**KIRKLEES METROPOLITAN COUNCIL  
INVESTMENT & REGENERATION SERVICE**

**DELEGATED DECISION TO DETERMINE PLANNING APPLICATIONS**

Reference No:	<b>2023/62/90256/W</b>
Site Address:	Shaley Farm, Shaley, Sandy Gate, Scholes, Holmfirth, HD9 1RY
Description:	Demolition of existing building and erection of new dwelling to be used as a holiday let
Recommending Officer:	Katie Chew

**DECISION – REFUSED**

Proposed side elevation (1:100)

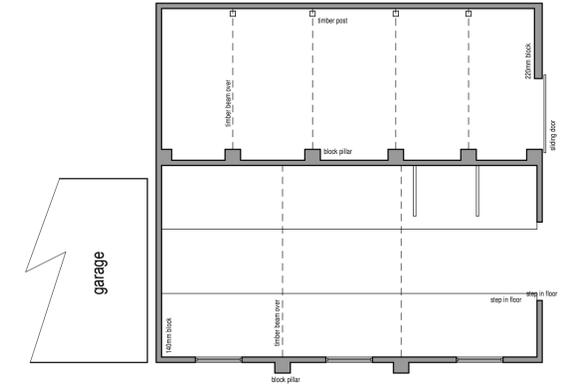
In respect of the openness of the Green Belt, openness has been established to have both a visual and spatial aspect. Whilst the proposed dwelling would be located on a similar footprint to the existing building, the dwelling would result in an increase to the overall height of the building by around 1.4m. The proposals would also introduce the off-street parking areas to the front of the building and a patio amenity area to the side, this would therefore increase the amount of built development, whilst also domesticating the site, and therefore the proposals would have an impact upon the openness of the Green Belt as a result of this.

In addition, the proposed dwelling whilst stepped back from the public highway, would be openly visible from Sandy Gate to the south. It is therefore considered that the overall scale and size of the proposals would be detrimental to the spatial aspects of openness. Furthermore, the nature of the use of the building would see greater levels of activity and associated domestic paraphernalia.

Existing layout plan (1:100)

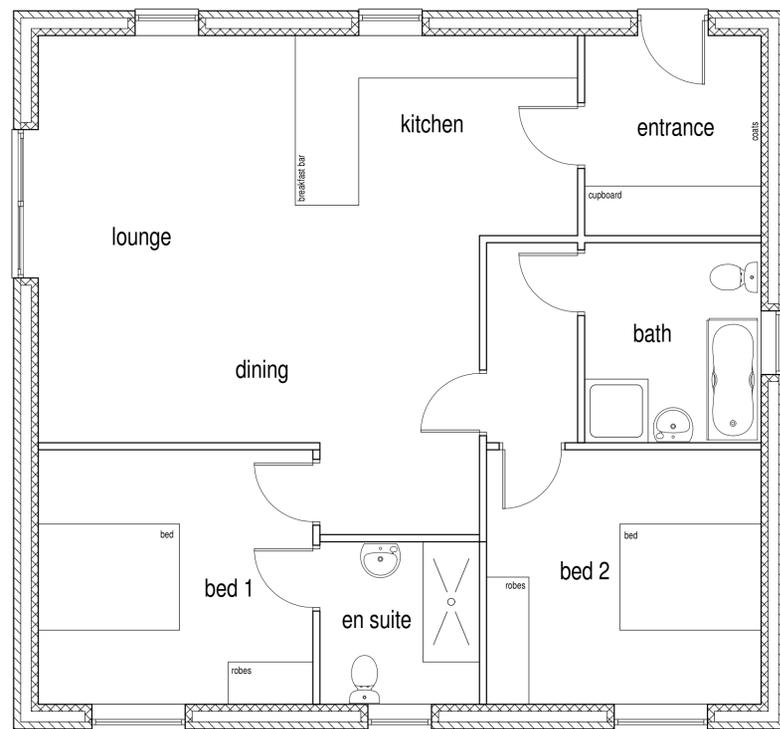
Furthermore, the building is currently used for agricultural purposes as a former cattle stall and for the storage of farm implements (as outlined within the submitted existing site plan) and therefore does not constitute brownfield/previously developed land and given the proposed use to residential would not be in the same use as existing, the proposals also do not meet any of the requirements of paragraph 149.
